Subject: Hydrant condition - A/96/21/PL Worthing Rugby Club, Beech Tree Childcare Roundstone Lane Angmering BN16 4AX

Having viewed the plans for planning application A/96/21/PL, and wanted to inform you there is insufficient supply of water for firefighting in the area, the supply of water i.e. a fire hydrant should be within 90 metres of a commercial property, currently the nearest fire hydrant is 240 metres away.

Title
Proposed Block Plan

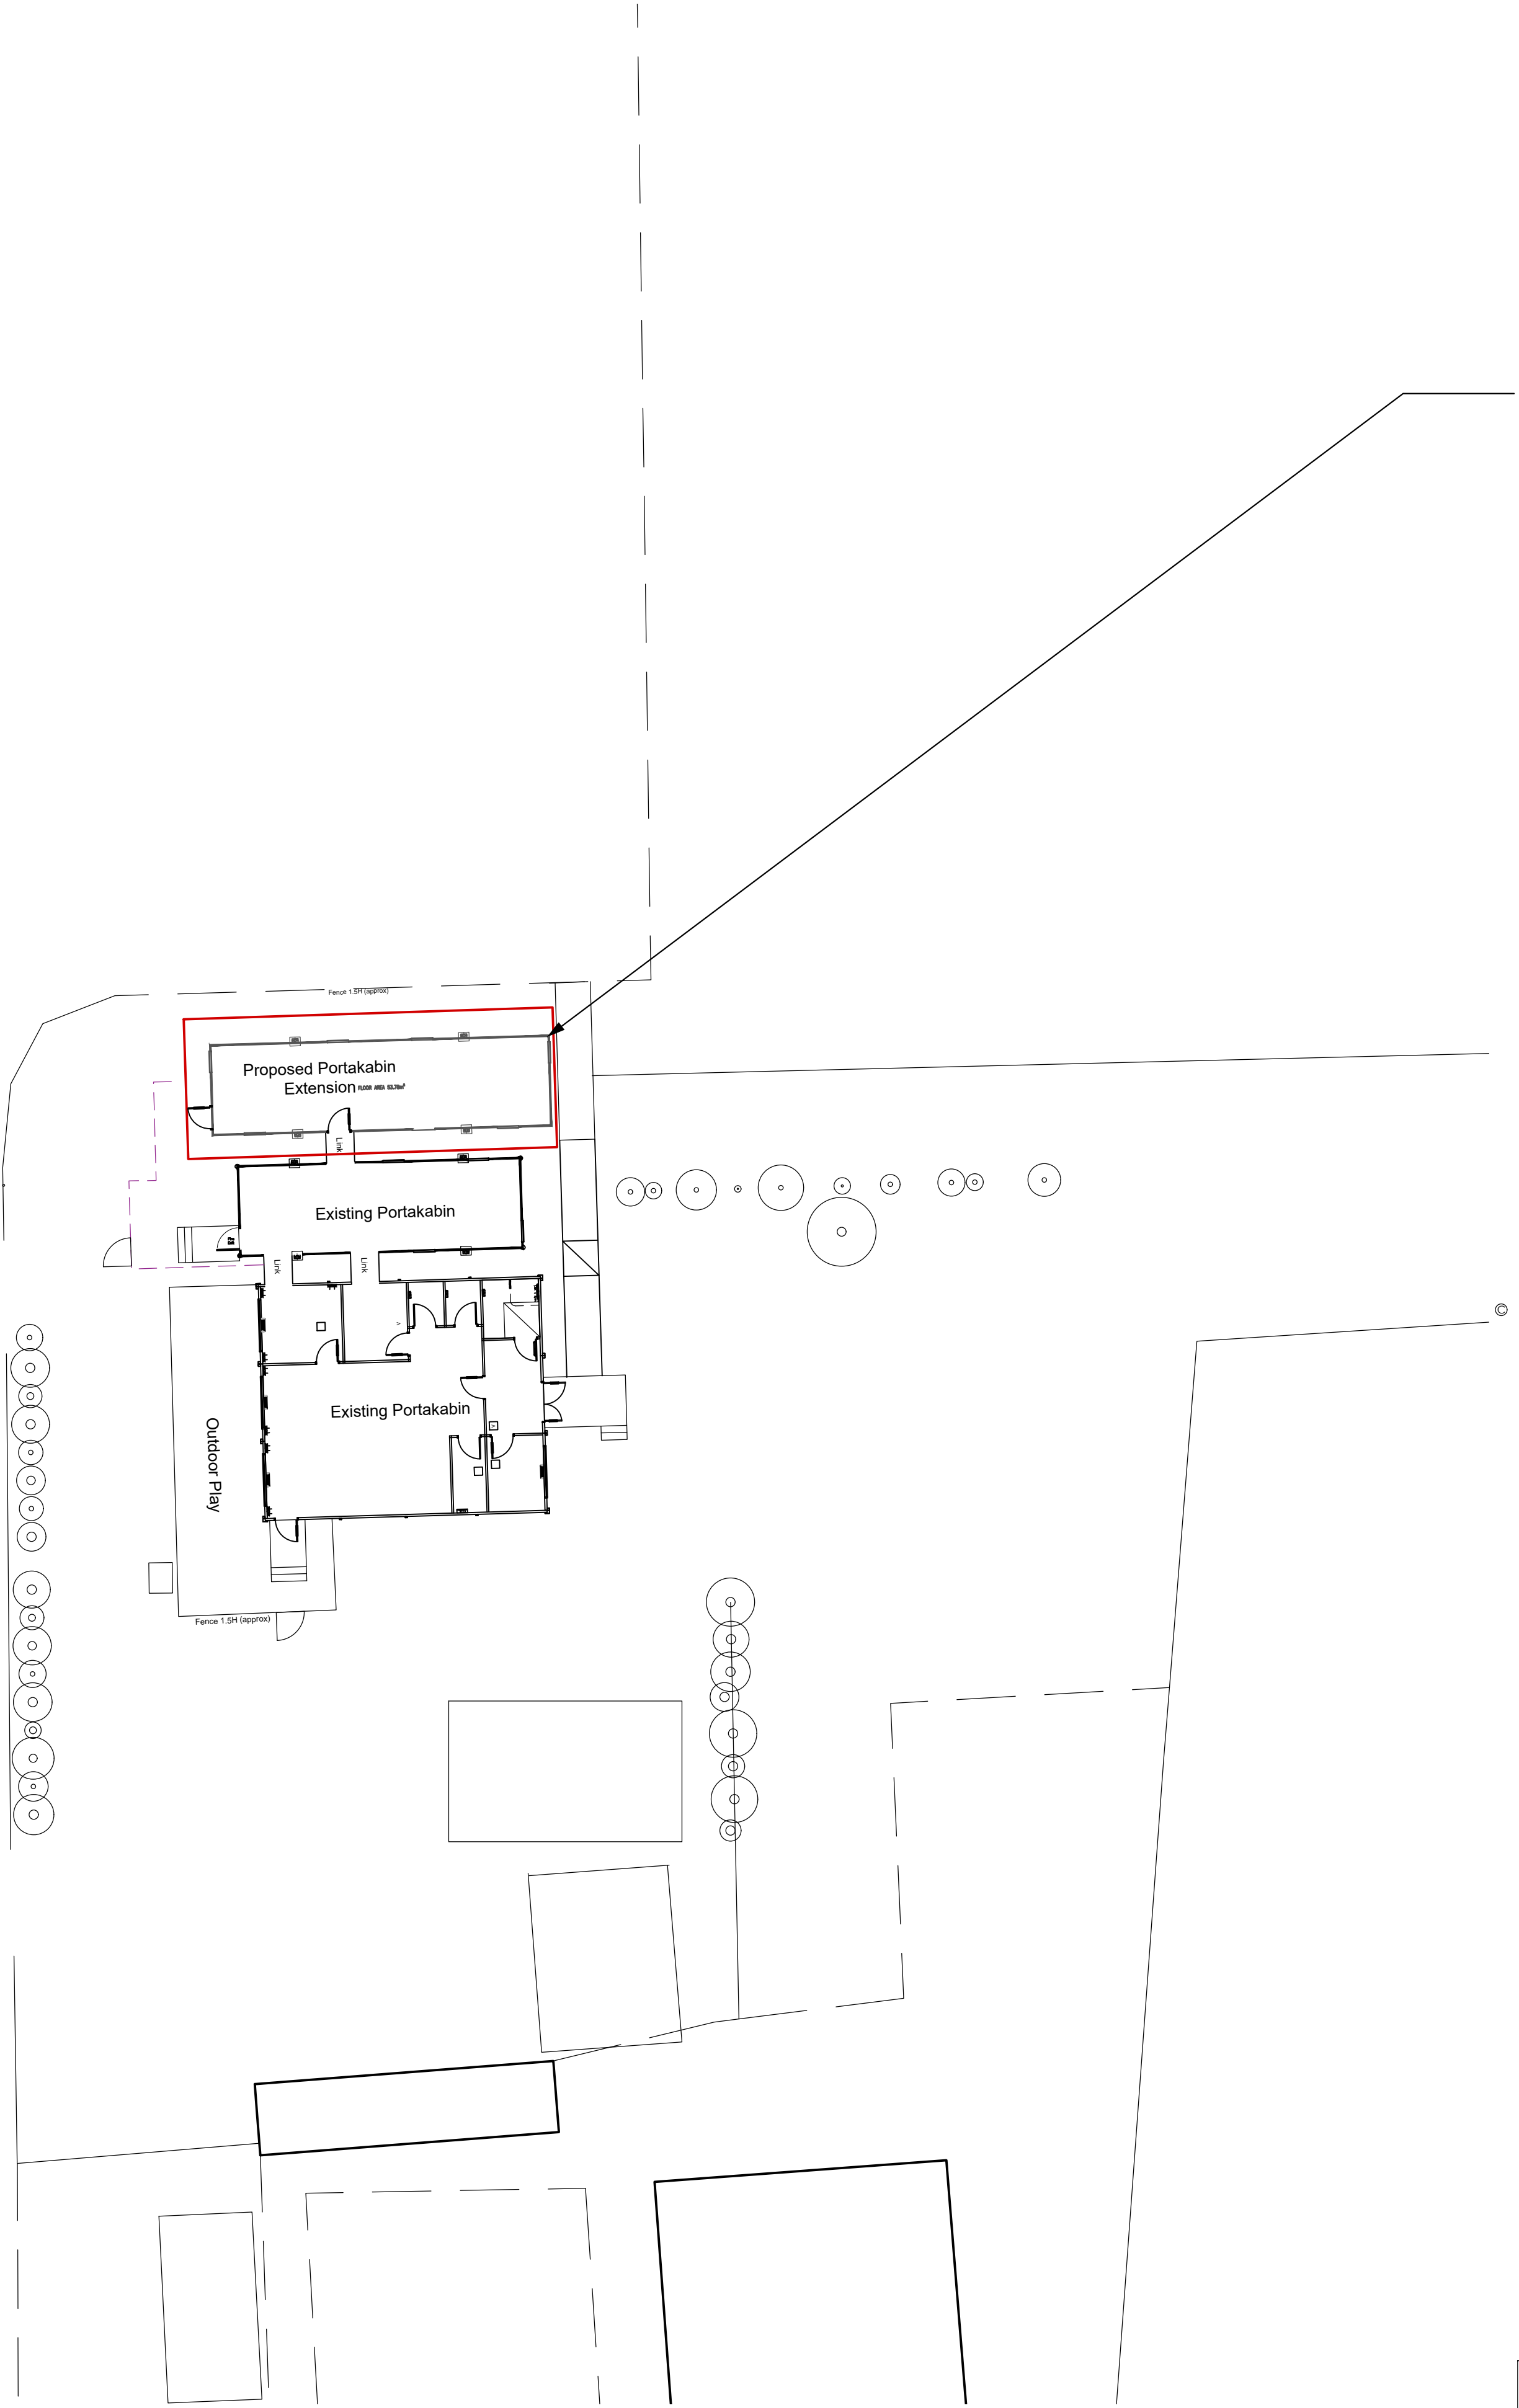
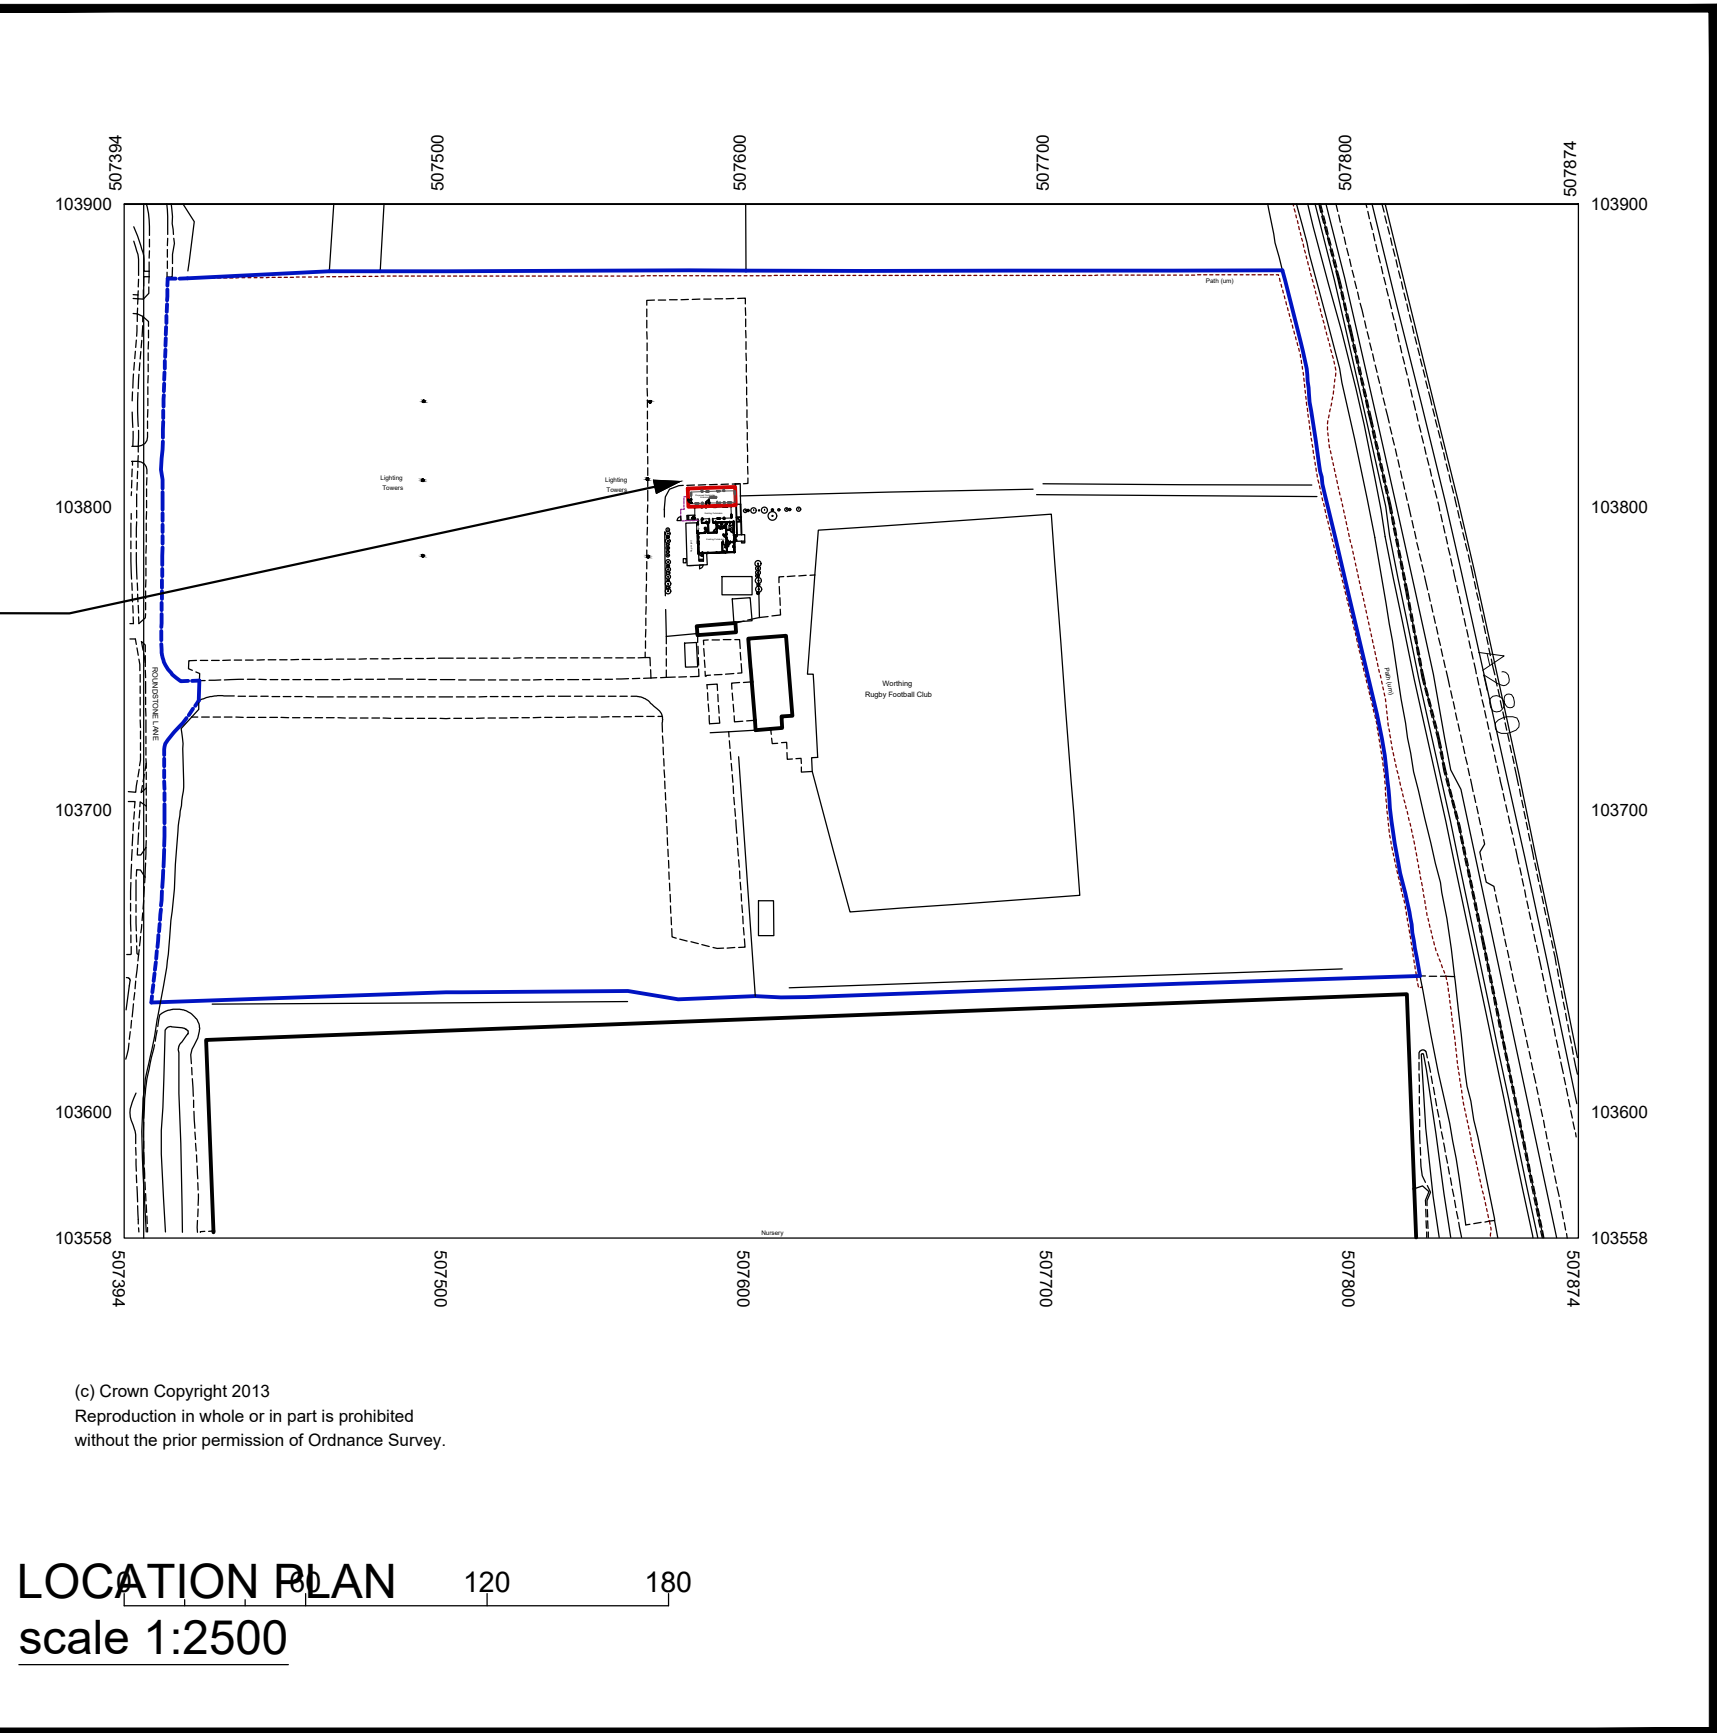
I appreciate this is an additional portacabin to be used for teaching, therefore this is to inform you, the developer and the owner / occupier of the short fall. In the event of a fire there is a possibility the fire appliance may run out of water before the fire is extinguished. The Fire Appliance only carries a certain amount of water supply hoses, that is why we require a water supply within this distance. As the nearest fire hydrant is 240 metres plus away, the Fire Crew would need the attendance of another fire appliance to have sufficient water supply hoses to reach the hydrant.
